Summary of Design Modifications – Revised S96 Application

Project No: 12022
Project: 4 Murray Rose Avenue
Date: 30 January 2017

SUMMARY OF REVISED S96 AMENDMENTS DESIGN MODIFICATIONS TO DEVELOPMENT CONSENT SSD 6076 MOD 1 4 MURRAY ROSE AVENUE, SYDNEY OLYMPIC PARK 2127

| Drawing Title | GENERAL | Context Elevation South and North    | Client | SSO SUBMISSION - S96 | Project No. | EA005 | Rev      | D  |

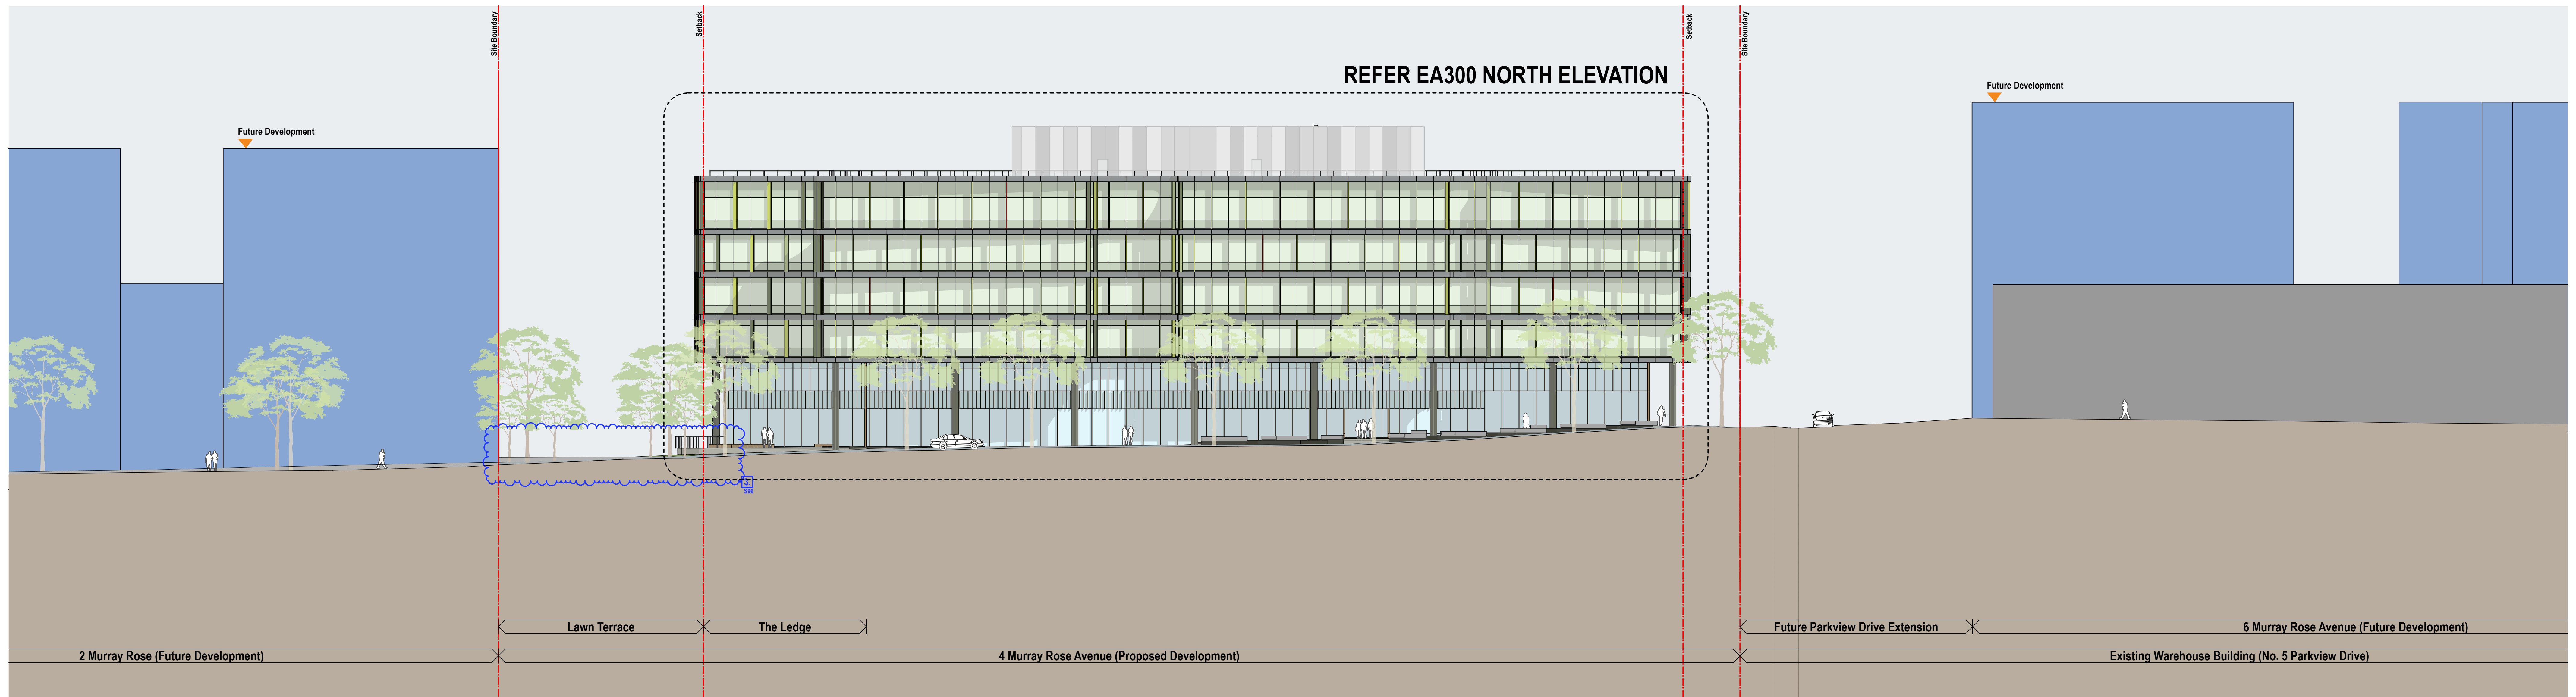
5.1 Due to the refinement of the building core, the façade has been adjusted reflecting the revised layout.

5.2 The Eastern façade has been modified to incorporate the revised location of the Eastern fire stair into the façade alignment.

Project Title
4MR
4 Murray Rose Avenue SOP NSW 2127 AU
Drawing Title
PLANS
Basement 03

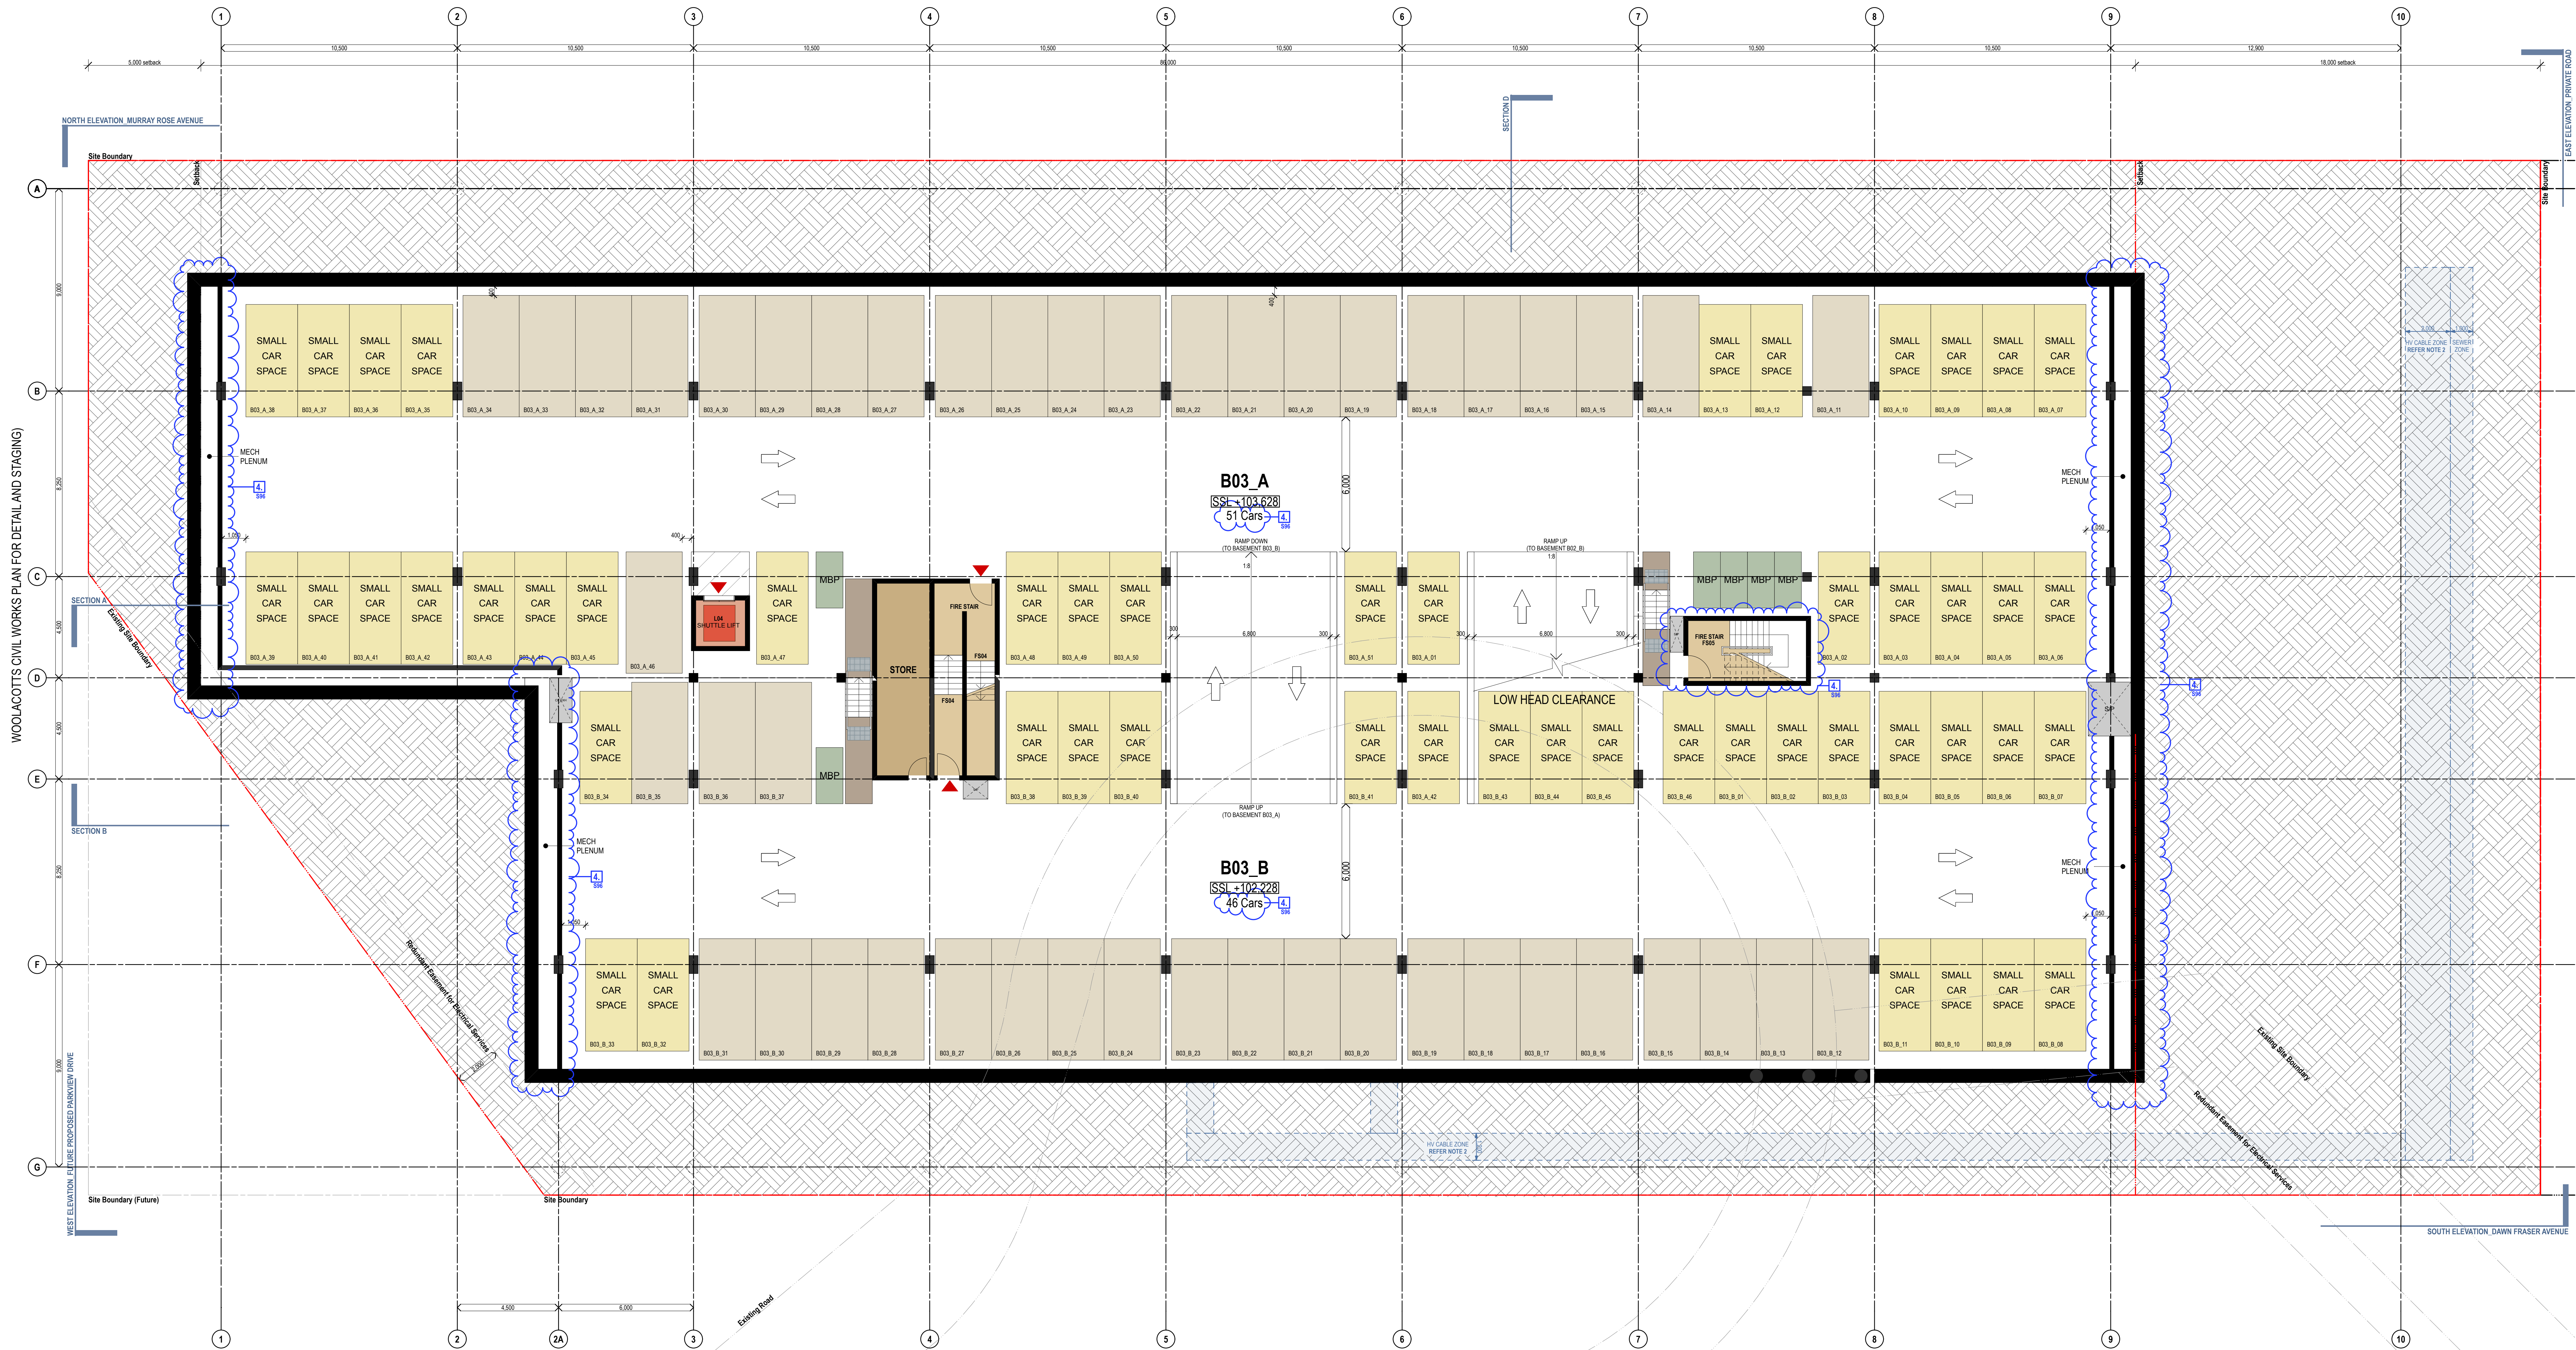
8.1 The allocation of car spaces has been modified to suit tenant requirements. Secure parking areas are provided on Basement 03 and 02, separated from the remaining area of car park by a roller shutter. 4WD car spaces with additional head clearance of 2.4m have been provided.

13.1 A diesel tank has been incorporated into Basement 03 following a specific tenant request. This resulted in the loss of two car spaces.
